TfNSW reference: WST24/00101/002| SF2024/056410
Your reference: SSD-50725707

TfNSW Response- SSD-507257078- EIS Exhibition Dinawan Wind Farm

TfNSW have reviewed the EIS and Appendix E -Traffic Impact Assessment prepared by EMM dated 28 May 2024 and the EIS – to inform this response.

DRAWING TITLE:
**STRATEGIC CONCEPT DESIGN
SWEEP PATH PLAN
A-DOUBLE**

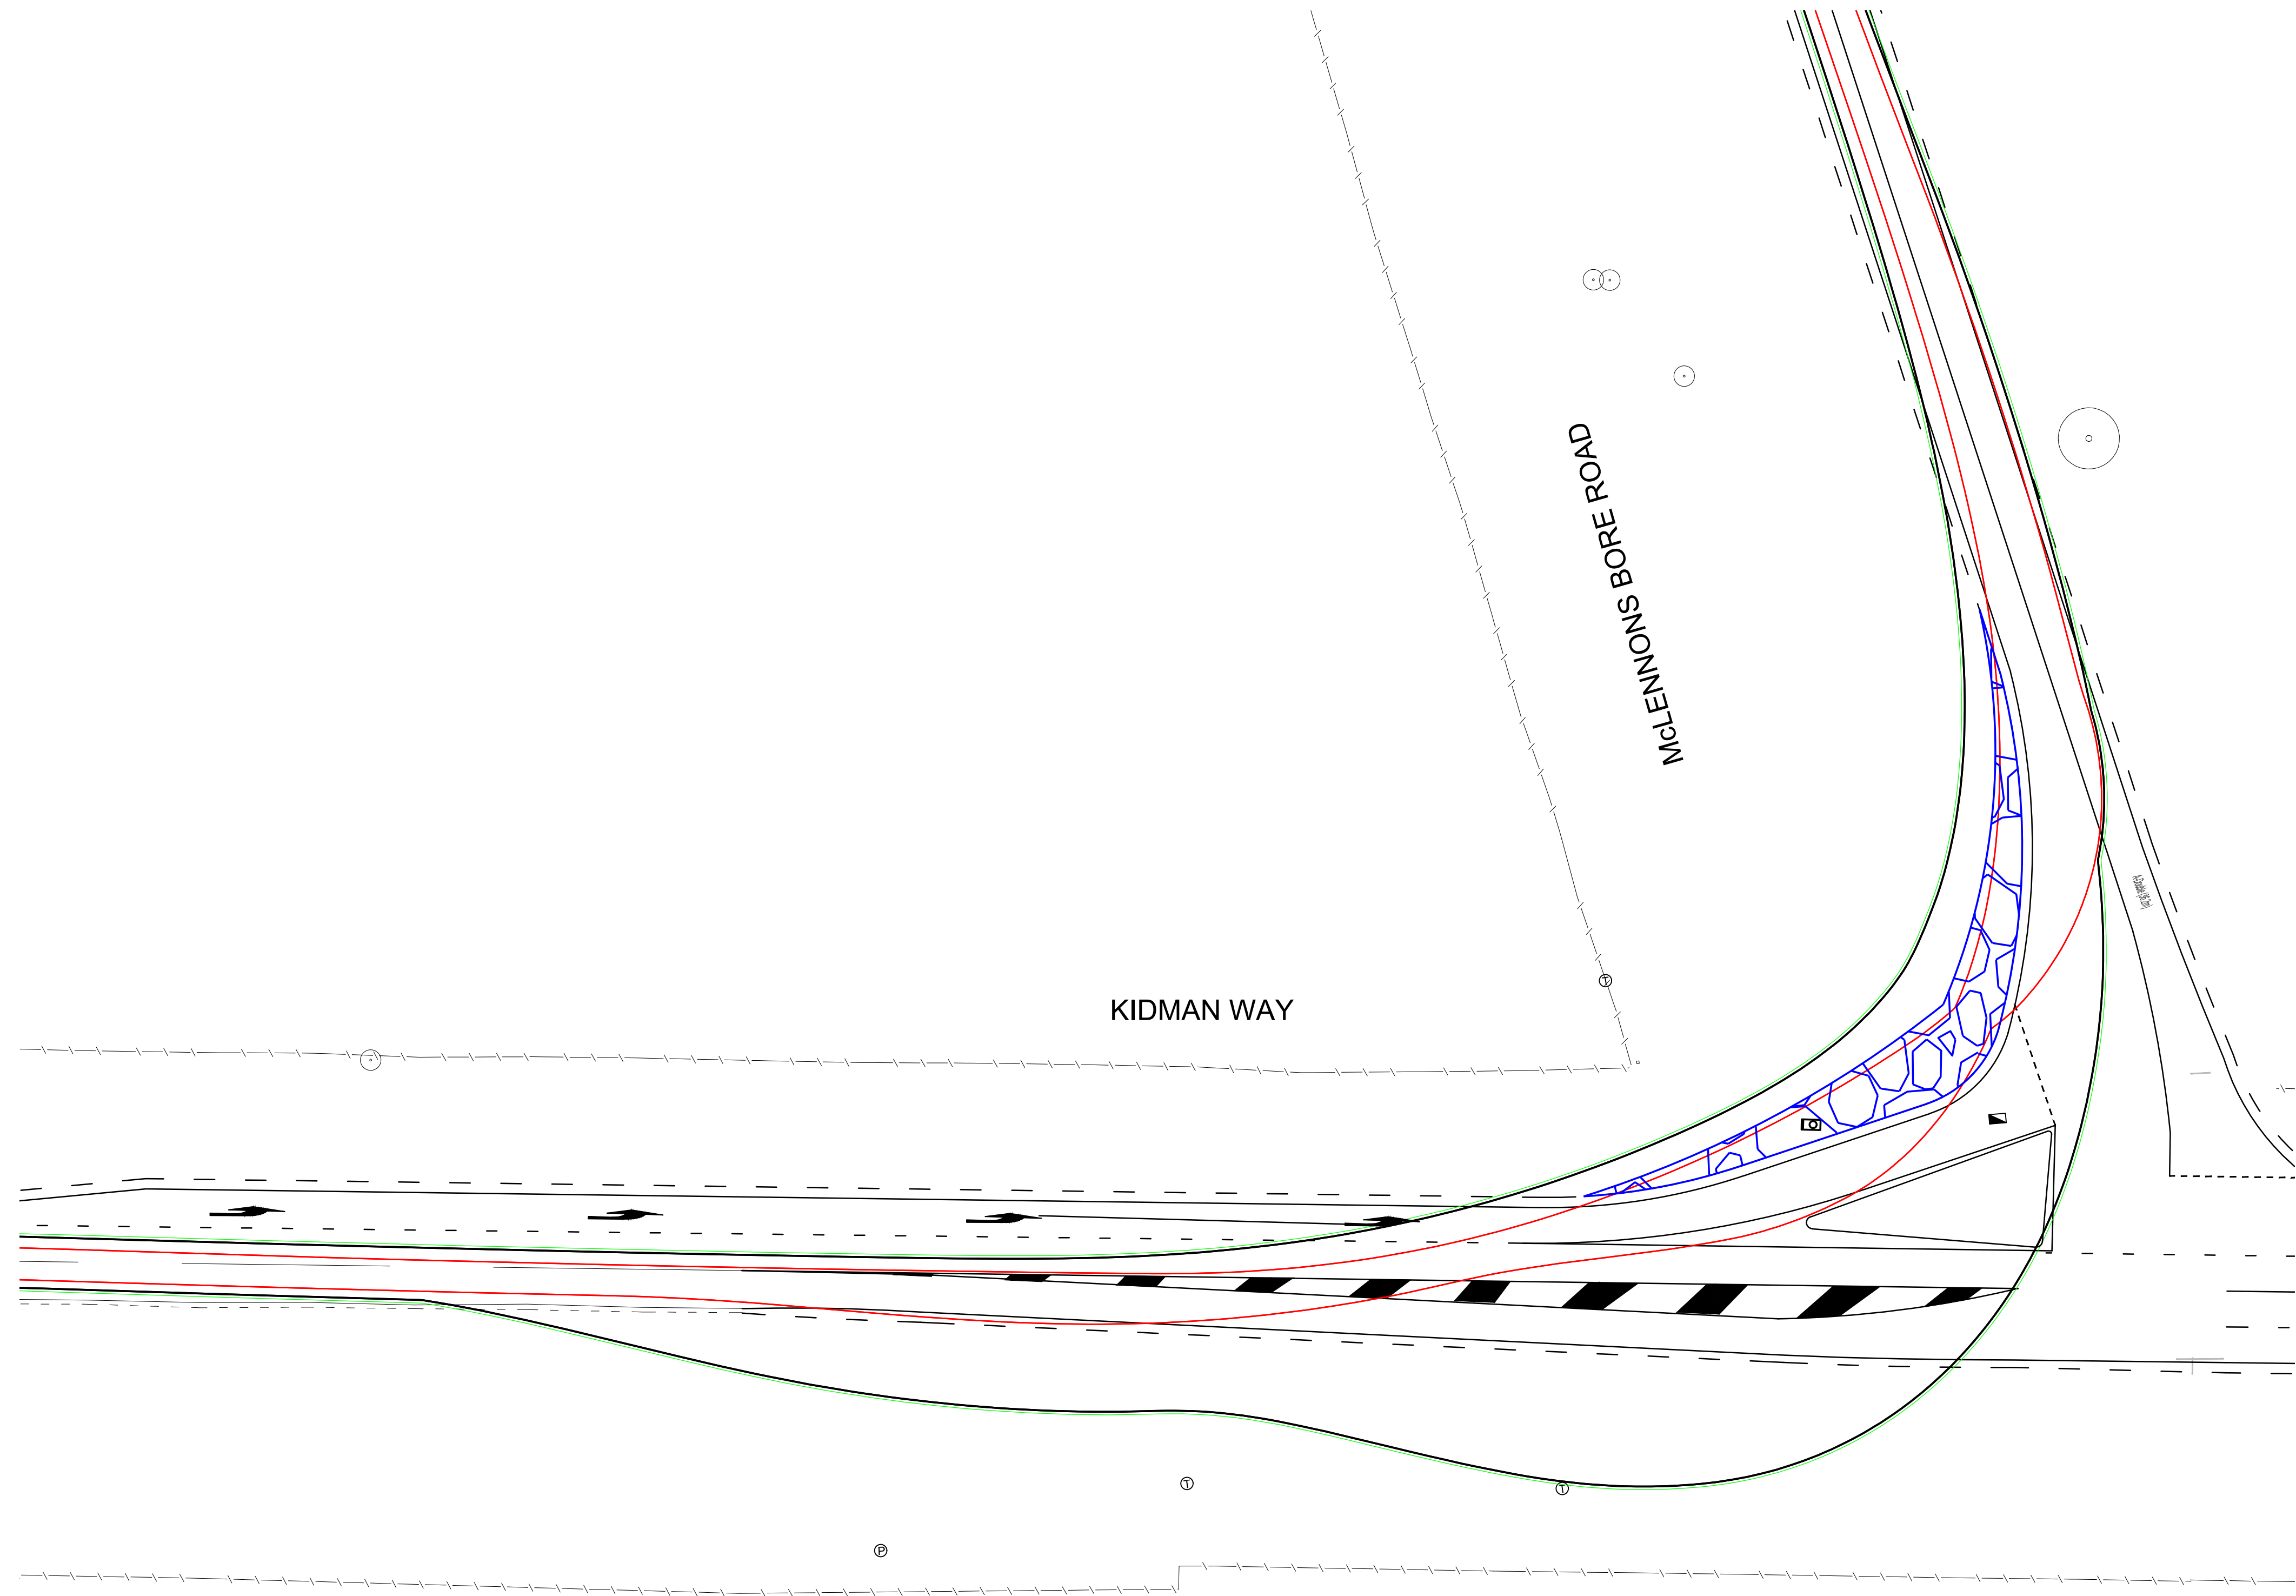
25. Strategic concept designs are required to be prepared for the proposed accesses to the Kidman Way, McLennons Bore Road/Kidman Way, and Cadell Road/Kidman Way intersections. They are to be submitted as part of the revised TIA traffic based on the outcome of the turn warrant assessment and accompanied by swept paths for the largest design vehicle for the project.

26. Strategic designs must be accompanied by swept paths for the largest vehicle required to access each public and private access with the state road network. Swept paths must demonstrate the largest heavy vehicle can turn concurrently in all turn directions without crossing into the incorrect lane, well within proposed/existing pavement and within existing intersection treatments (where applicable). Intersection upgrades are to be in accordance with Austroads and relevant TfNSW supplements.

DRAWING TITLE:
STRATEGIC CONCEPT DESIGN
SIGNS AND LINEMARKING PLAN

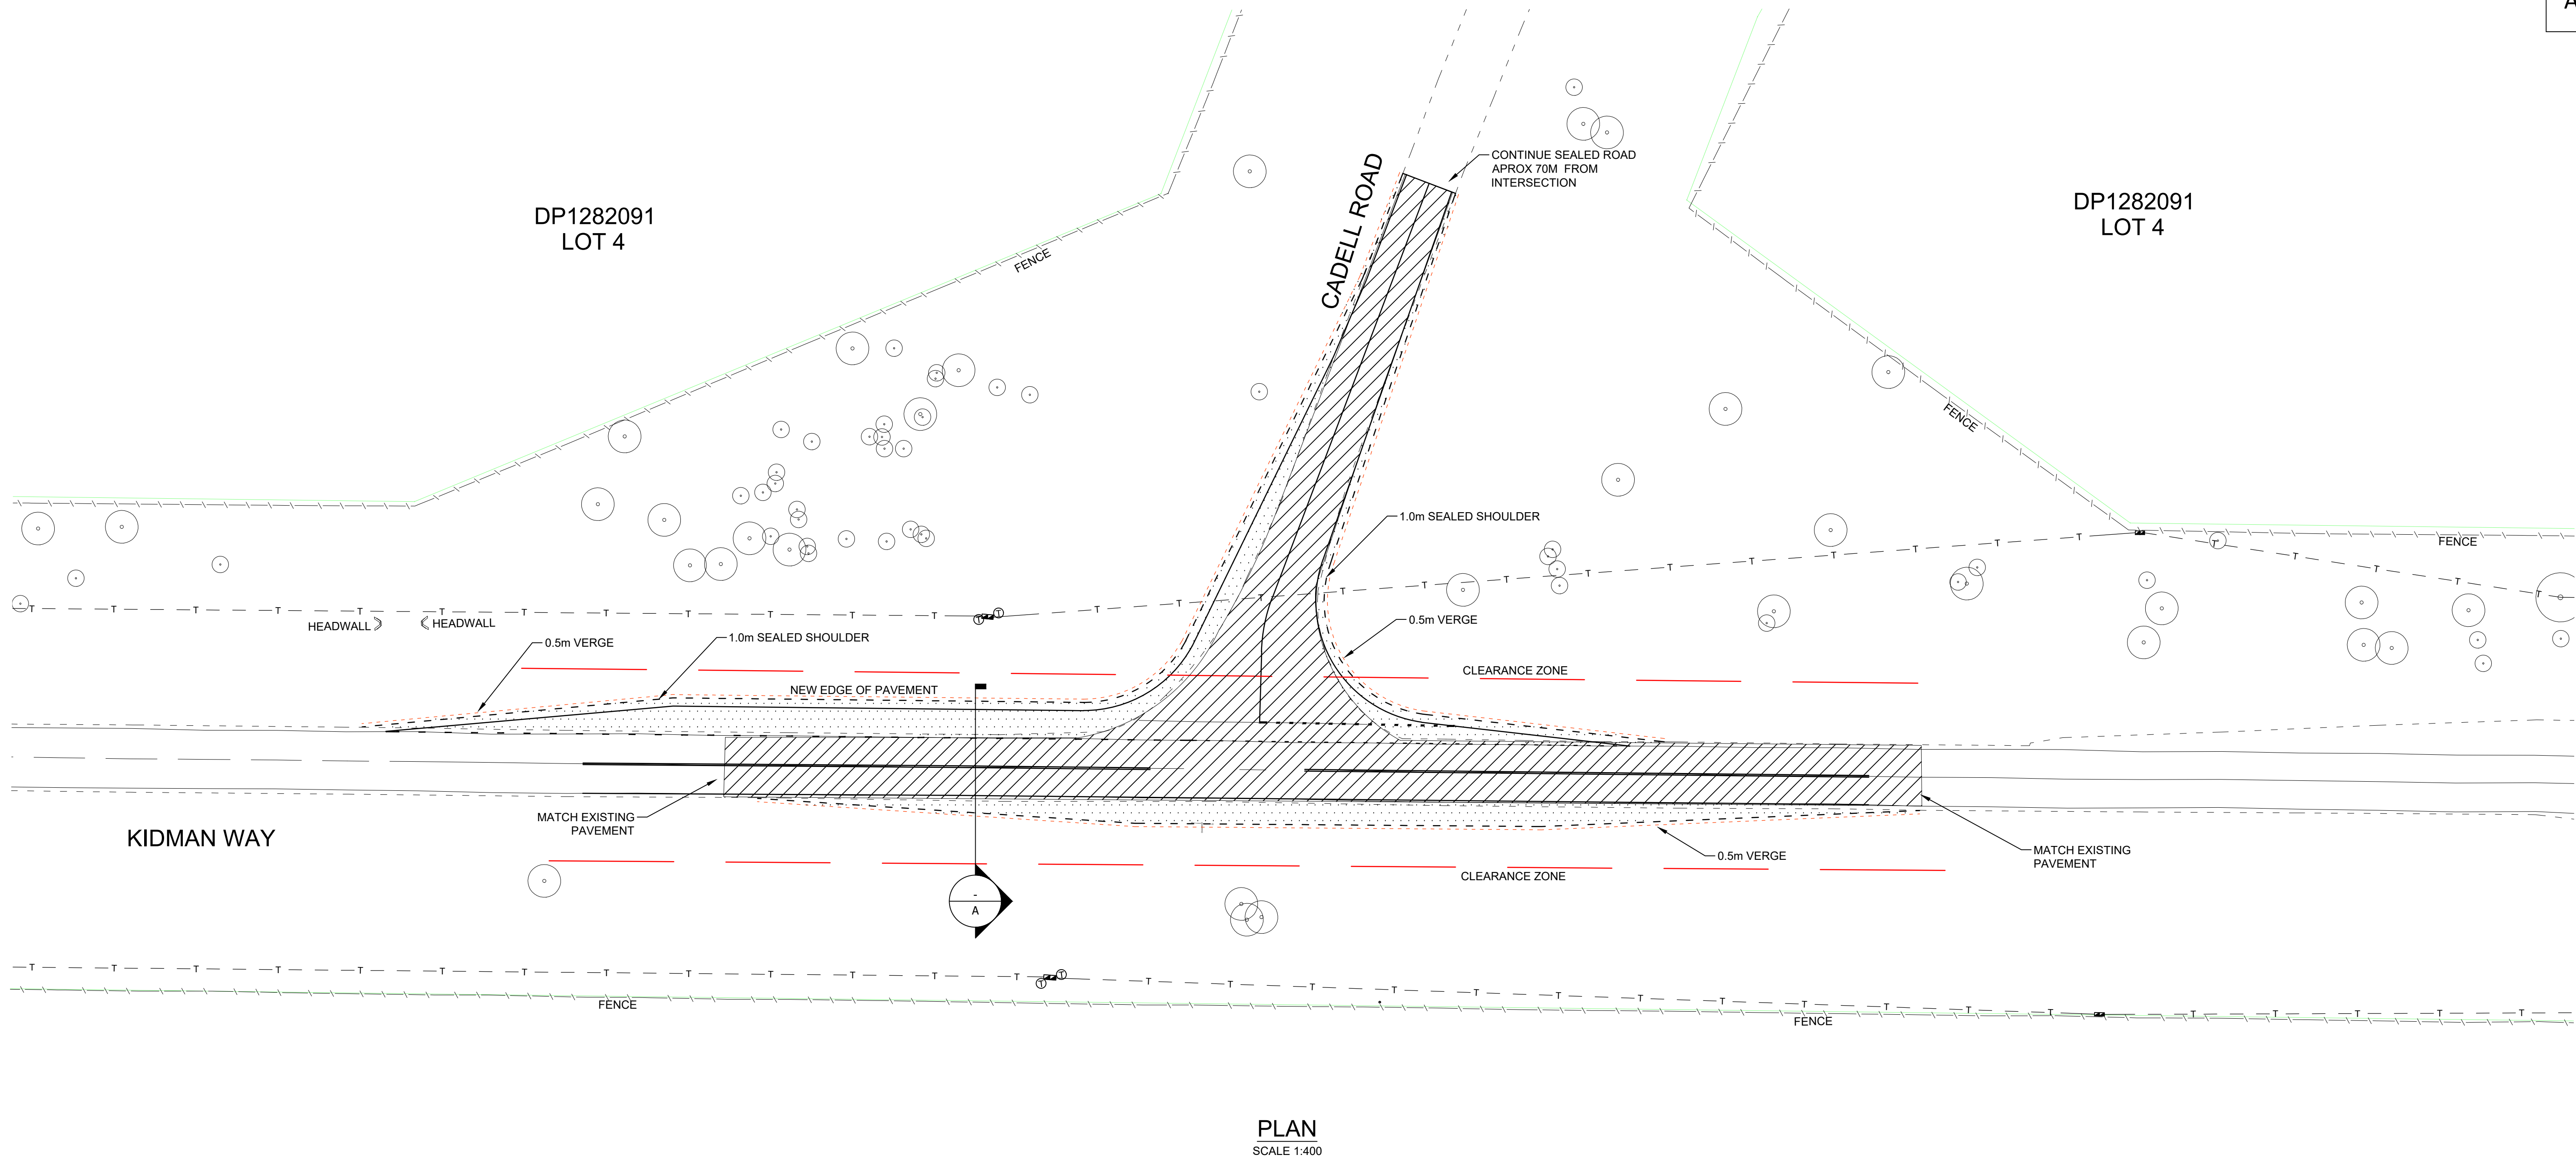
Lower priority issue- The Kidman Way/Cadell Road intersection identifies a right turn restriction. The revised TIA must provide additional information detailing how the prohibition will be enforced and monitored throughout the project.
